Permit Number: 091211

has permission to Remove existing front porch, rebuild new front porch slightly larger

AT 46 HOWARD ST City of Portland 014 E00900 **NOV 23 2009**

PROJECT NAME: Converse Porch Expansion

$dw\ 14 \times 38'8" = 541.36\text{ft}^2$

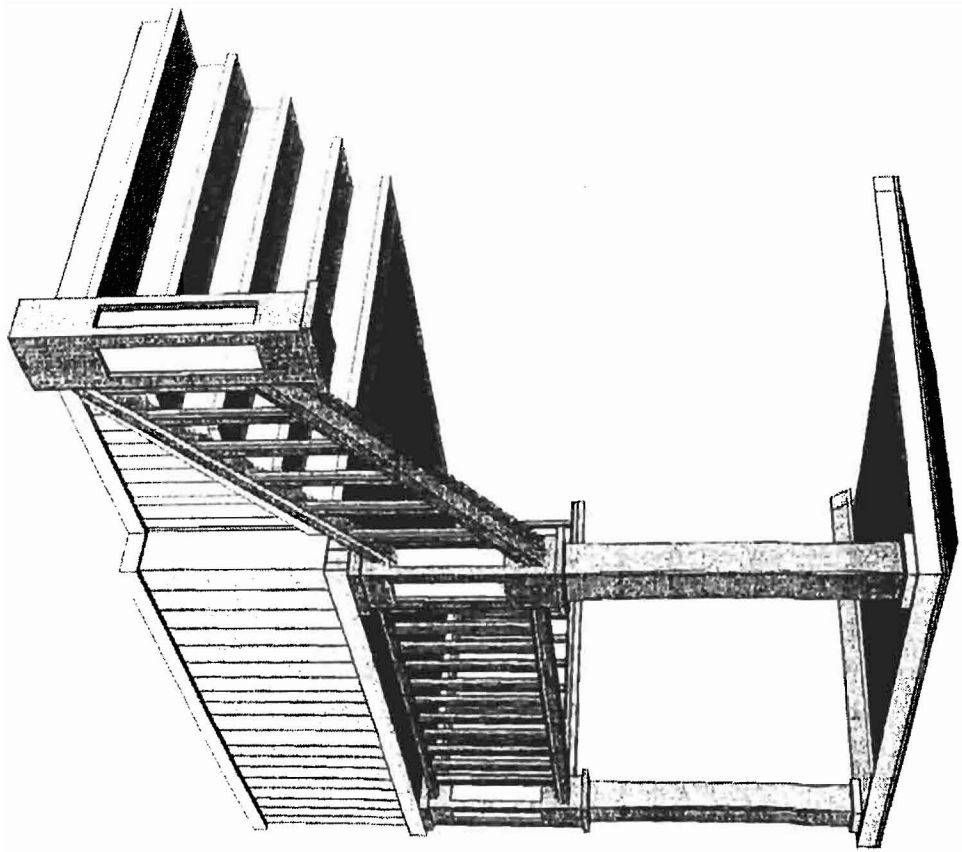
<b>Comments:</b>
11/2/2009-amachado: Left vcm for Derek Converse. Need to know the existing setbacks for the buildngs on either side of 46 Howard to see what the average setback is. Need to know the open space ratio is being met; what is the sf of the driveway? Need siteplan exemption application filled out.
11/3/2009-amachado: Spoke to Derek. He will get me the necessary information and the siteplan exemption application.
11/4/2009-amachado: Gave siteplan exemption application to planning. Received information on neighbors setbacks and impervious surface area.

Existing Condition  
 46 Howard Street  
 See site plan submitted \*  
 11/4/09  
 average setback 15'

R-1  
 lotsize - 2912  
 land area per du = 1,220 sq ft  
 front 10' average - 1' proposed  
 side - 10' - 21' 3"  
 rear - NA

lot coverage = 50% = 1480 - 1248.34  $\phi$  OK  
 \* open space 20% = 592 - see site plan - submit with  
 11/4/09  
 existing setbacks  
 dw = 541.33 sq ft  
 house = 1248.34 sq ft  
 1170.29 open space
